From: Brendan.M Hurley <Brendan.M.Hurley@fire.nsw.gov.au>
Sent: Thursday, 19 November 2020 2:52 PM
To: Emma Barnett
Cc: Fire Safety
Subject: Notice of Exhibition – Minto Resource Recovery Facility (SSD-5339). BFS20/3278

Notice of Exhibition – Minto Resource Recovery Facility (SSD-5339)

Fire & Rescue NSW (FRNSW) acknowledge the receipt of your email on the 16th October 2020, requesting input into the Environmental Impact Statement (EIS) for the Minto Resource Recovery Facility (SSD-5339).

DRAWING TITLE <b>EARTHWORKS SECTIONS SHEET 03</b>				
PROJECT NO. <b>P1203464</b>	PLANSET NO. <b>PS02</b>	RELEASE NO. <b>R21</b>	DRAWING NO. <b>PS02-C705</b>	REVISION <b>A</b>

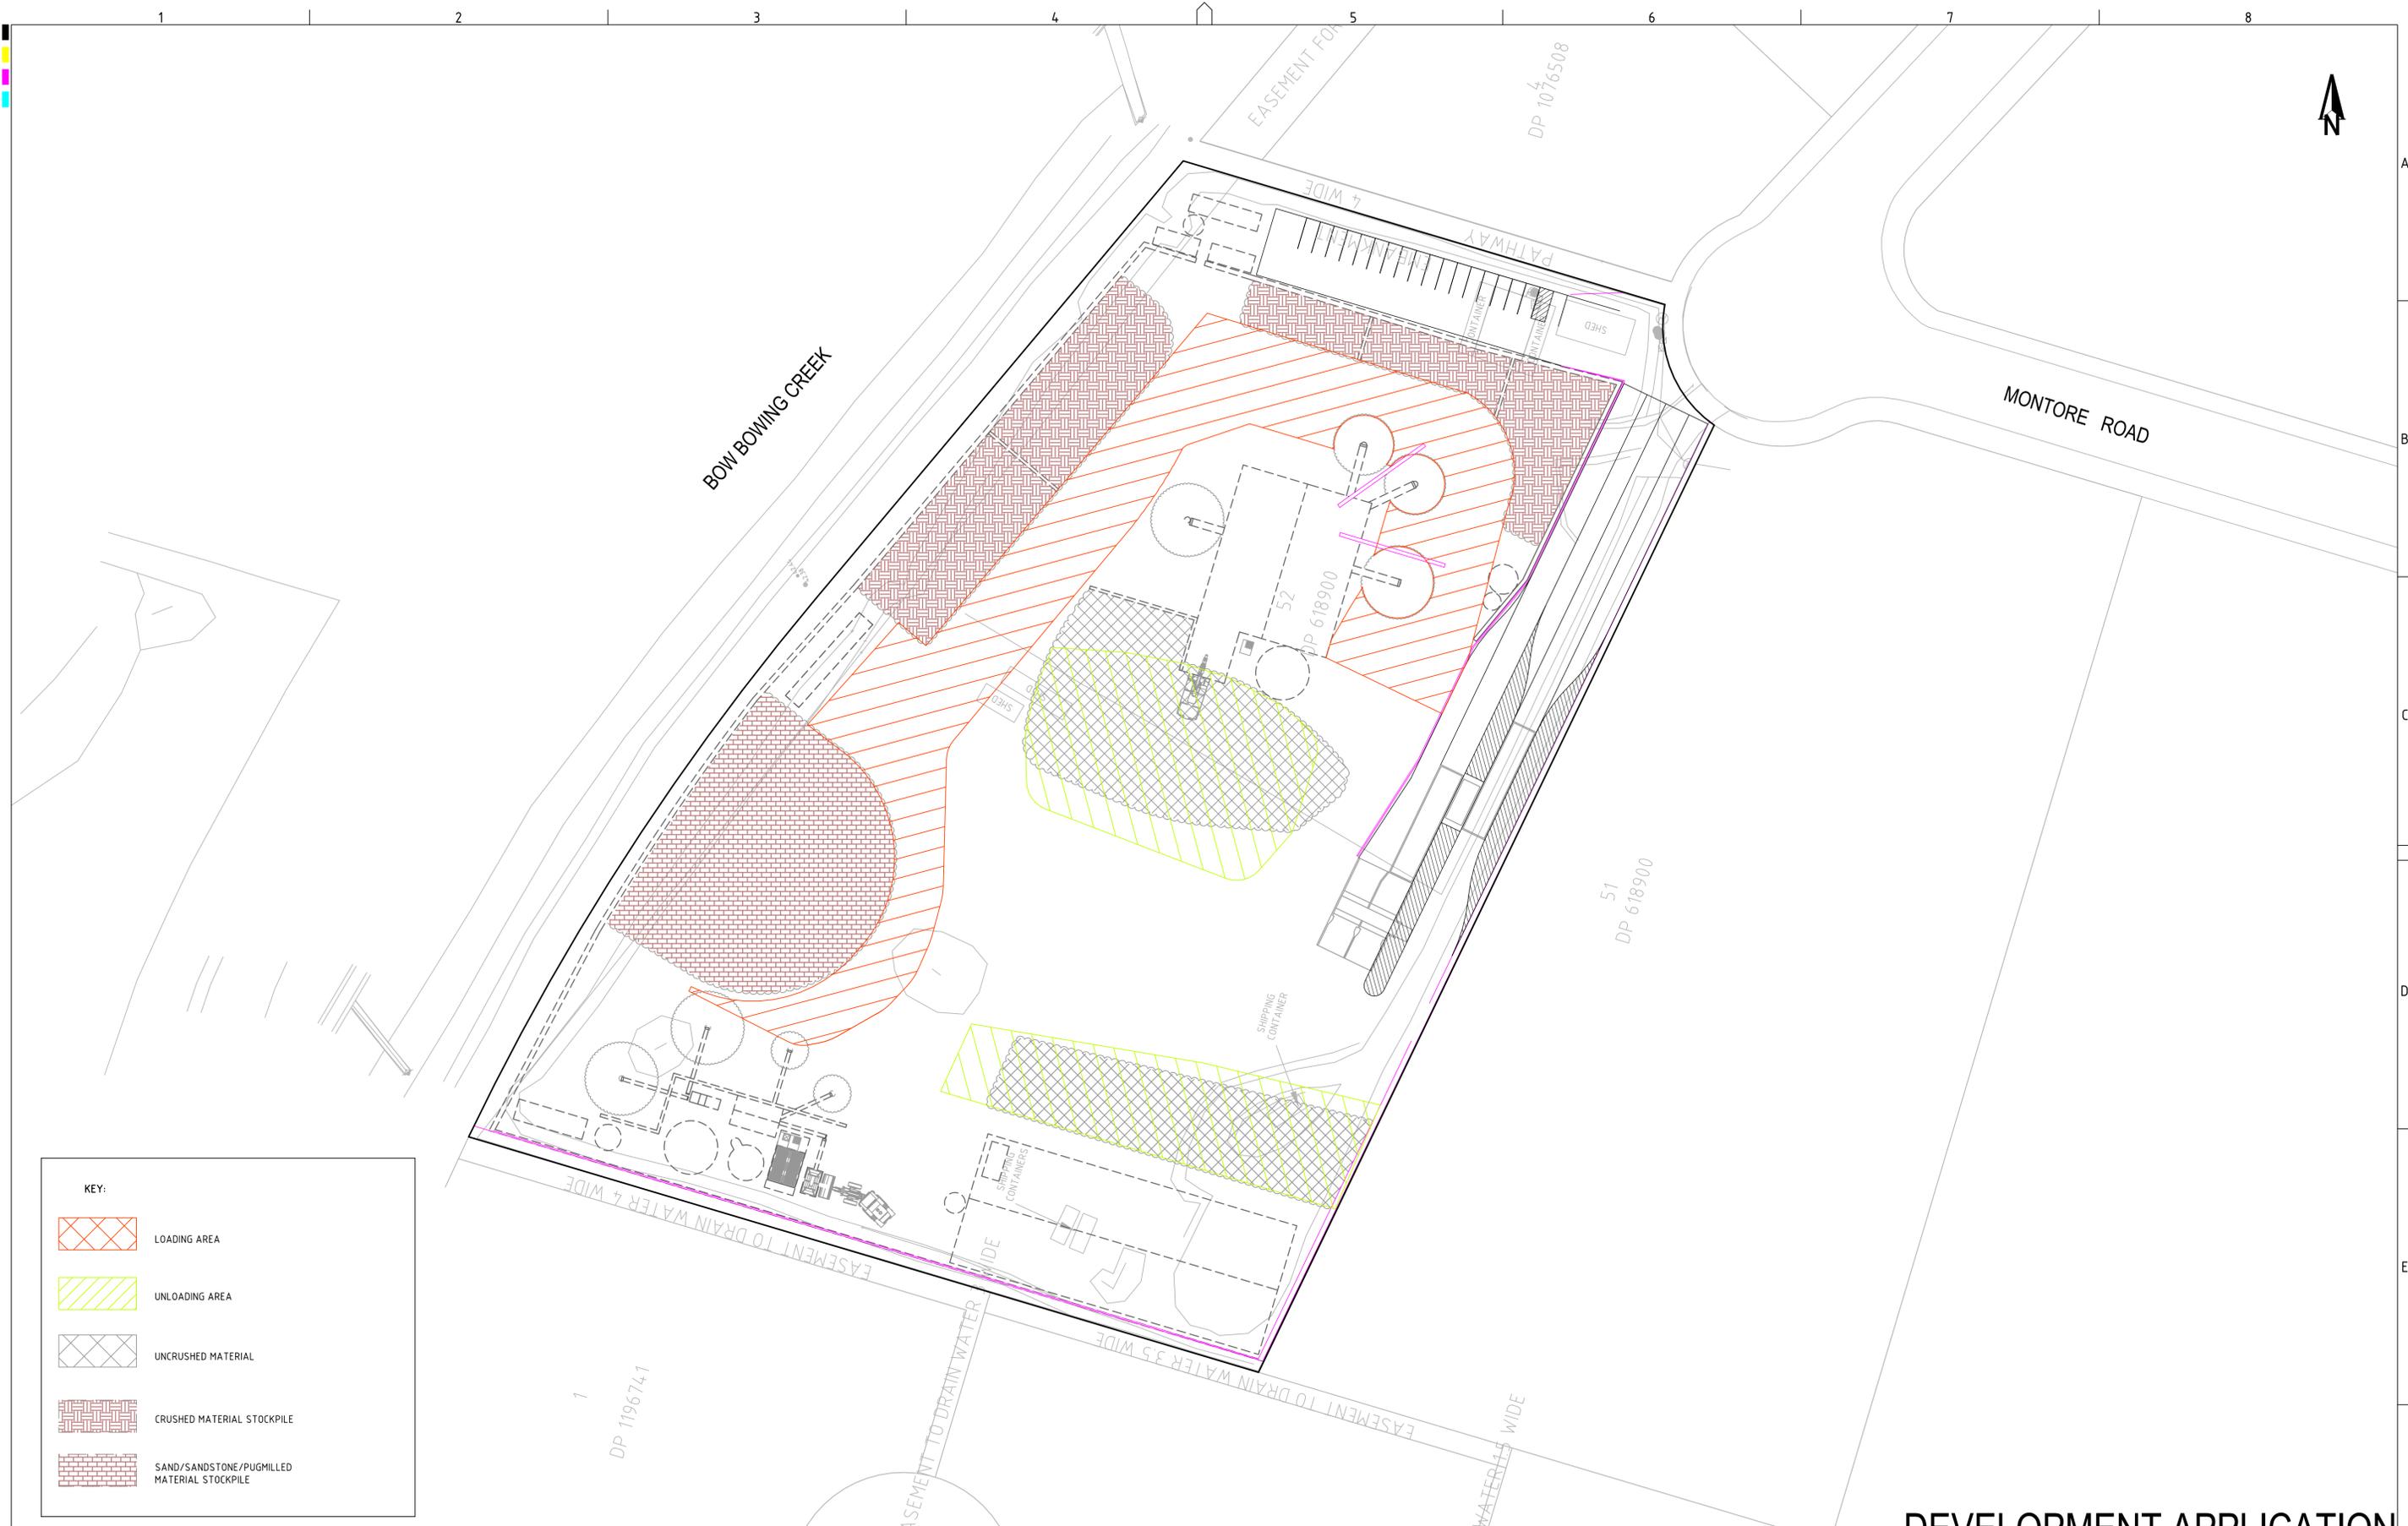
- It is recommended that the stockpile plan be updated to include specific locations, sizes (heights included), separation and vehicle access distances as per FRNSW's Fire Safety Guideline.
